# CITY OF ALBUQUERQUE

**Re: Daycare Center**  
**515 Old Coors Dr. SW**  
**Traffic Circulation Layout**  
Architect's Stamp dated 12-05-16 (K11-D086)

**Re: Daycare Center  
515 Old Coors Dr.  
Traffic Circulation Layout  
Architect's Stamp 11-21-16 (K11-D086)**

SITE PLAN / TRAFFIC CIRCULATION LAYOUT
SCALE: 1/8" = 1' - 0"

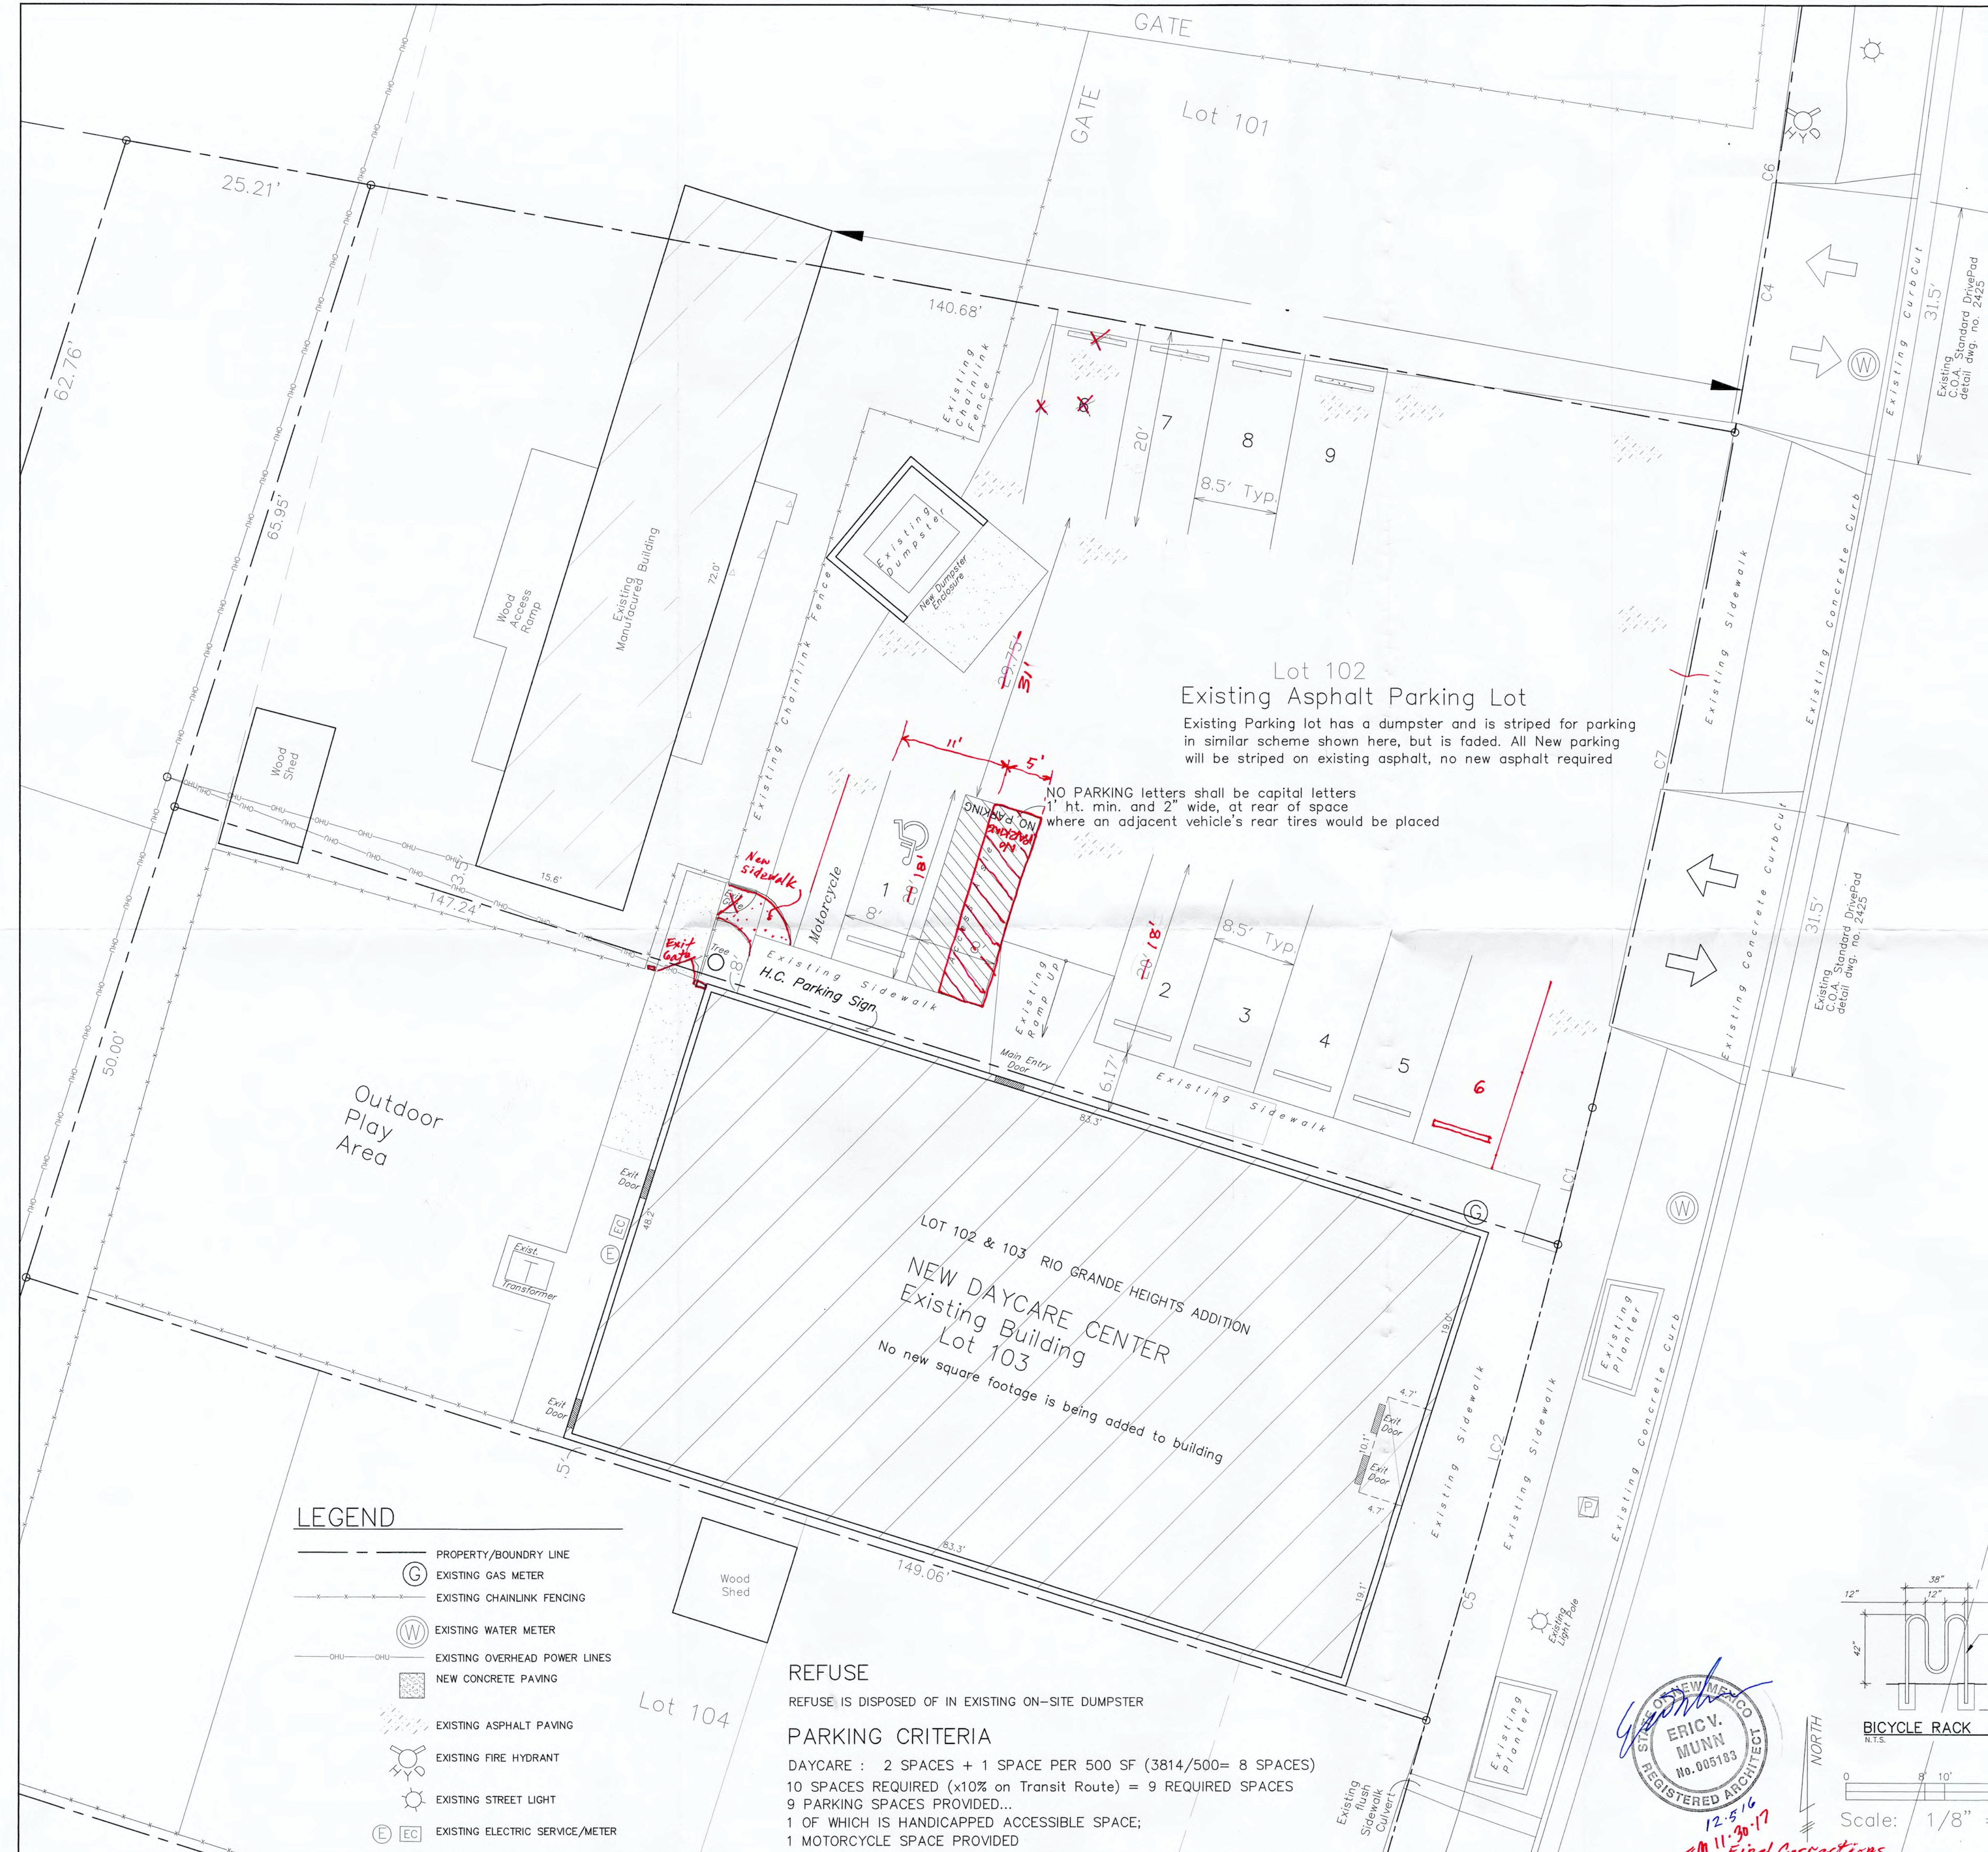
1. The handicap accessible spaces must include an access aisle. Van accessible aisles should be 8ft wide; all others should be 5ft wide.
2. The ADA accessible parking sign must have the required language per 66-7-352.4C NMSA 1978 **"Violators Are Subject to a Fine and/or Towing."** Please call out detail and location of HC signs.
3. The ADA access aisles shall have the words **"NO PARKING"** in capital letters, each of which shall be at least one foot high and at least two inches wide, placed at the rear of the parking space so as to be close to where an adjacent vehicle's rear tire would be placed. (66-1-4.1.B NMSA 1978)
